FRANKLIN FACADE

NEWBURY FACADE

**BUILDING ELEVATIONS**

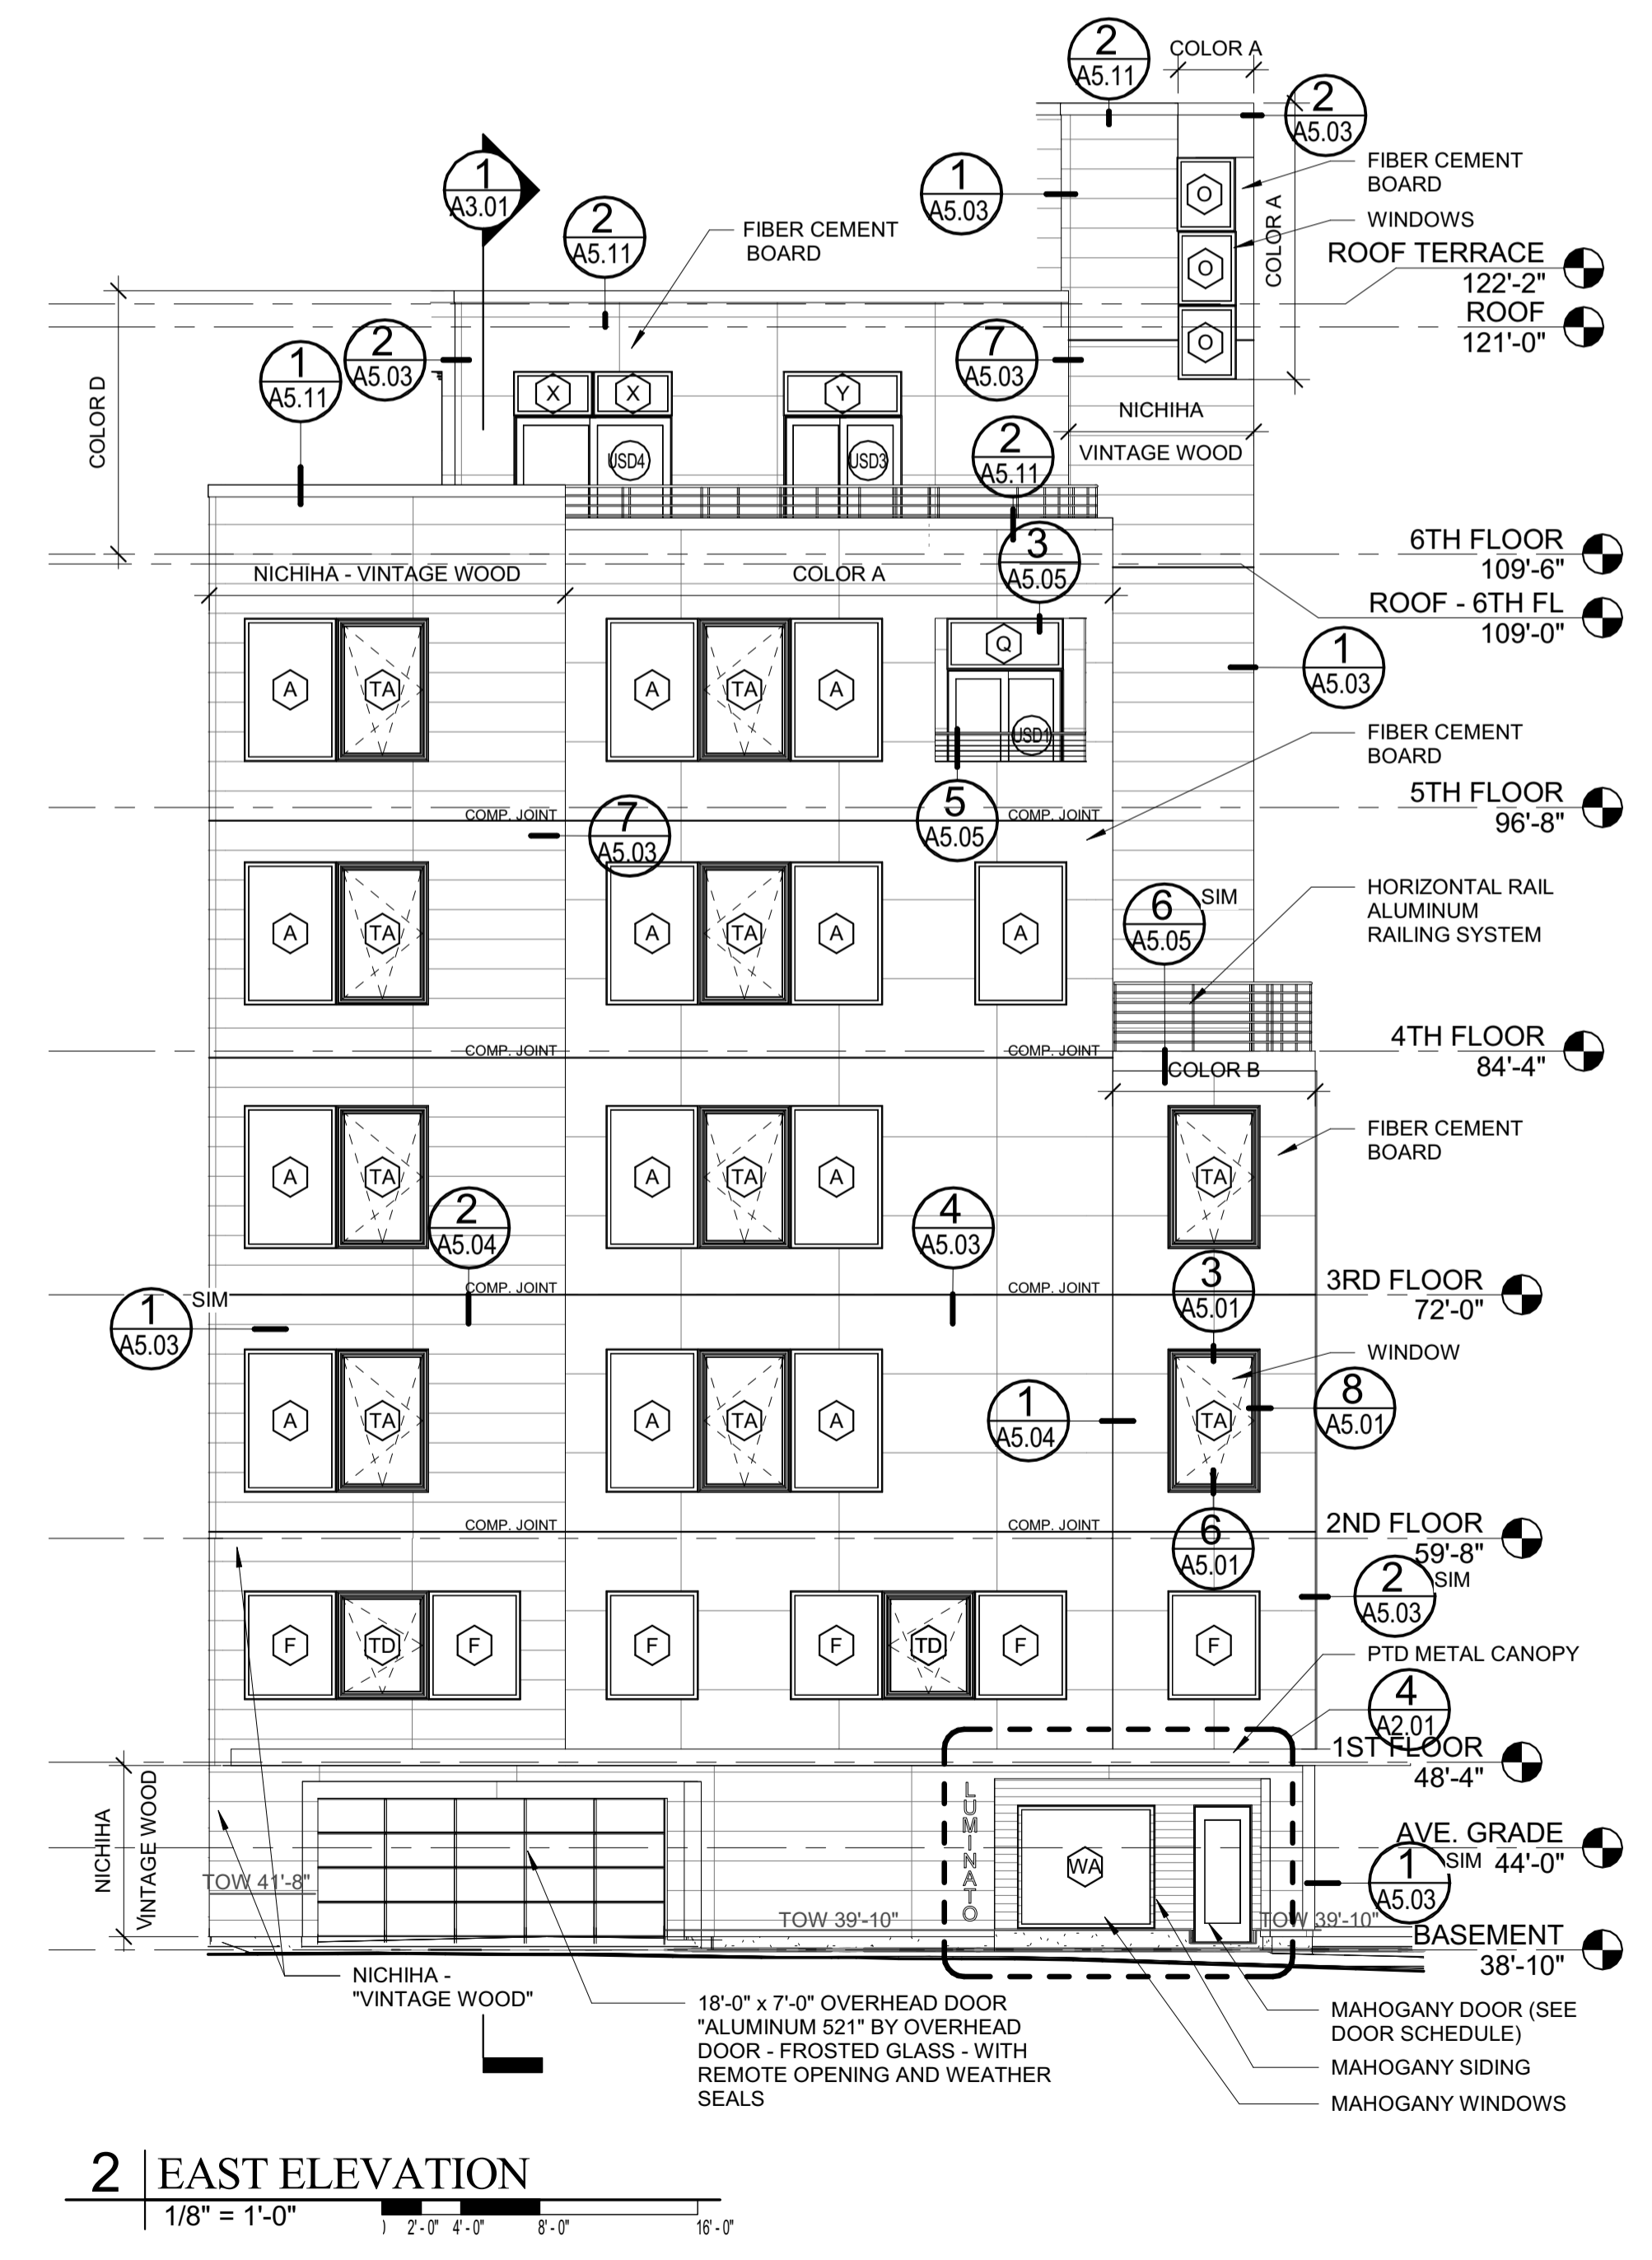
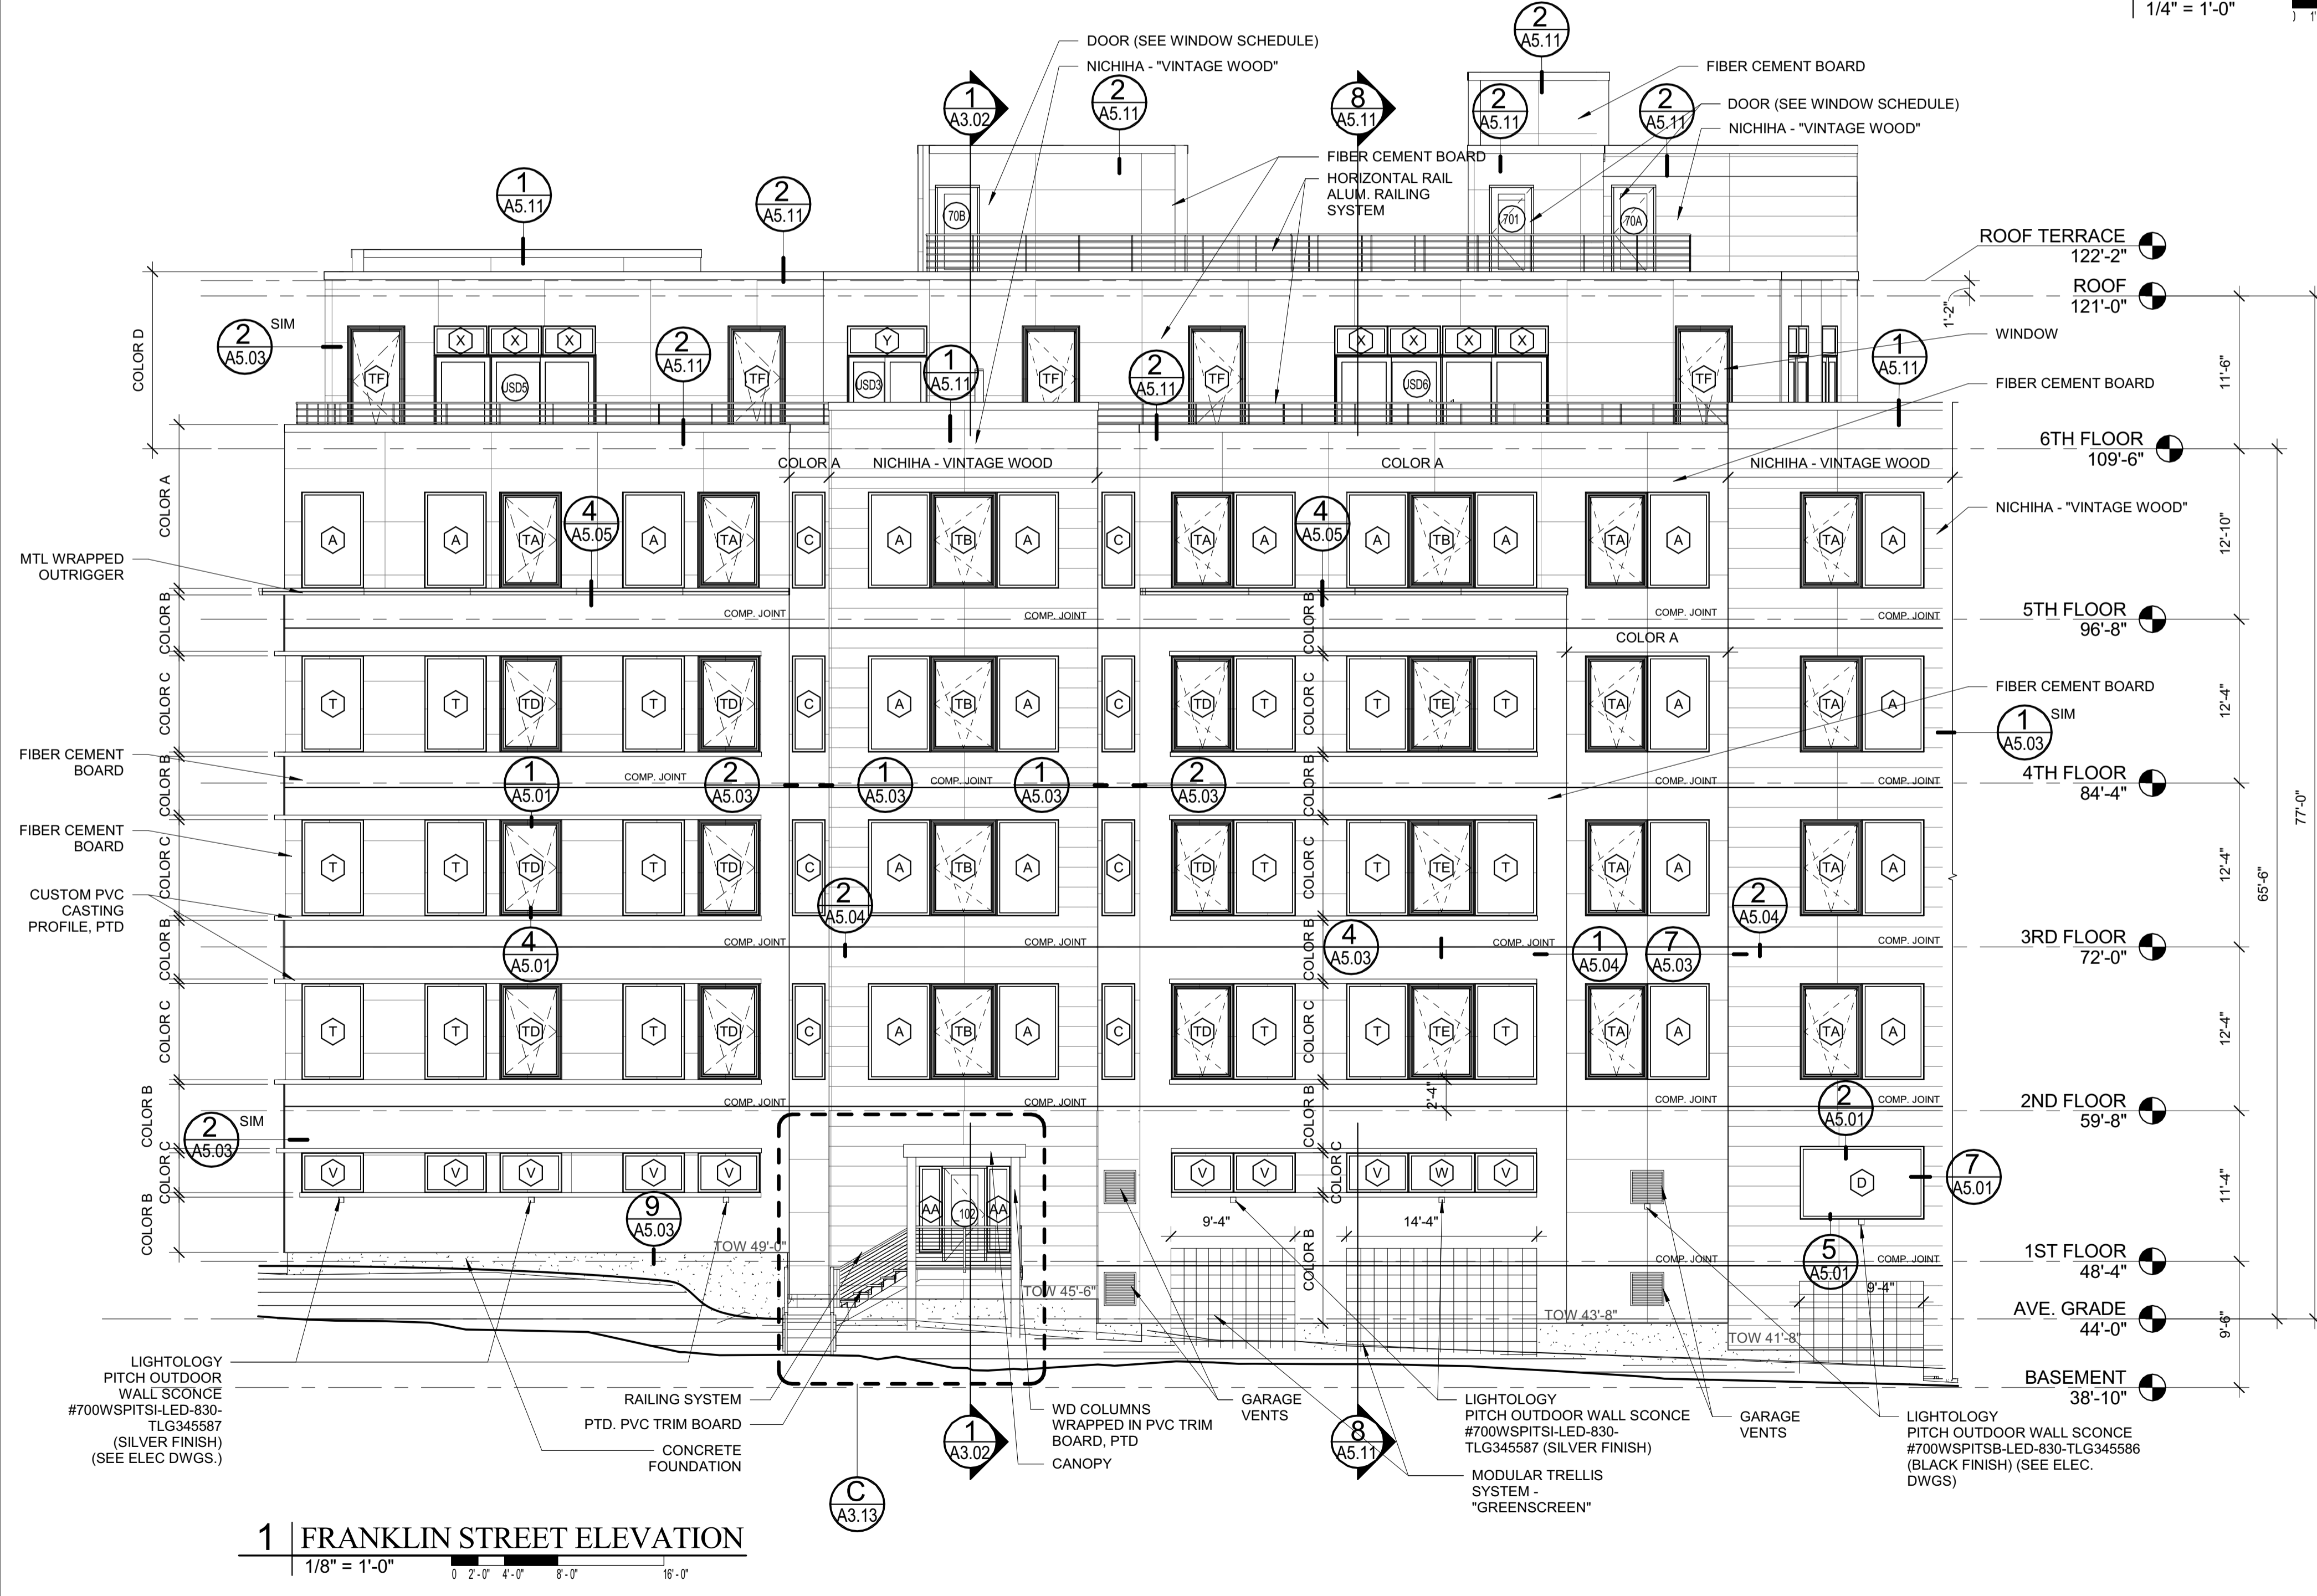
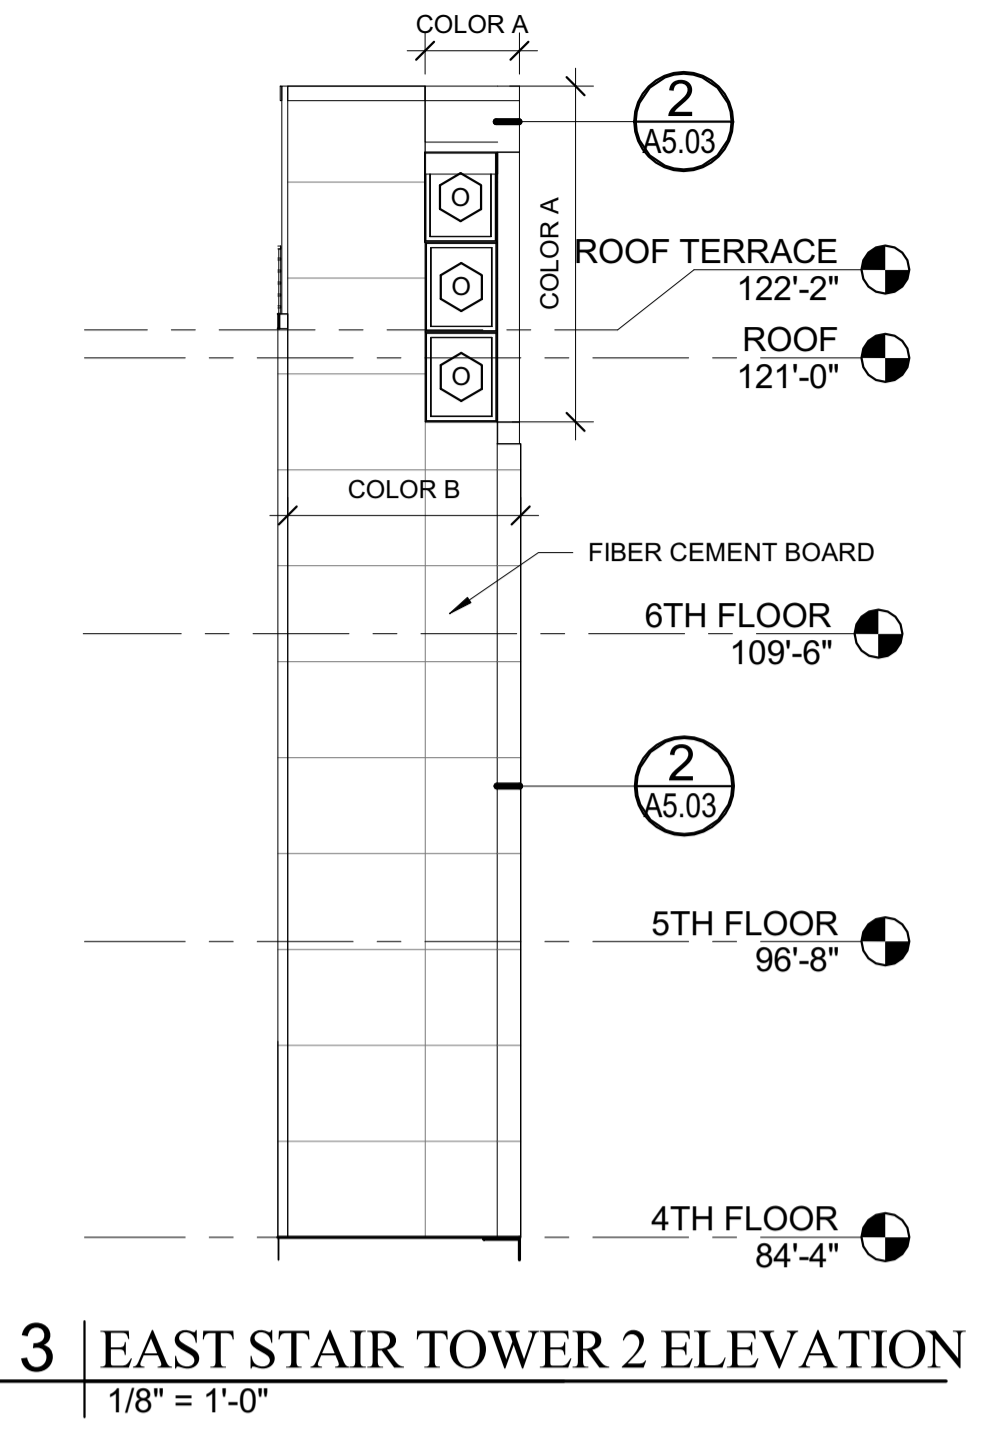
- Lighting + landscaping could activate Franklin facade
- In general, carry materiality of upper floors down to garage level
 - cladding material brought lower
 - two indentations brought down to ground
 - windows added to top garage level
- Base material more similar to rest of architectural palette in color

Emphasize corner w/ more height

Bring material down slightly
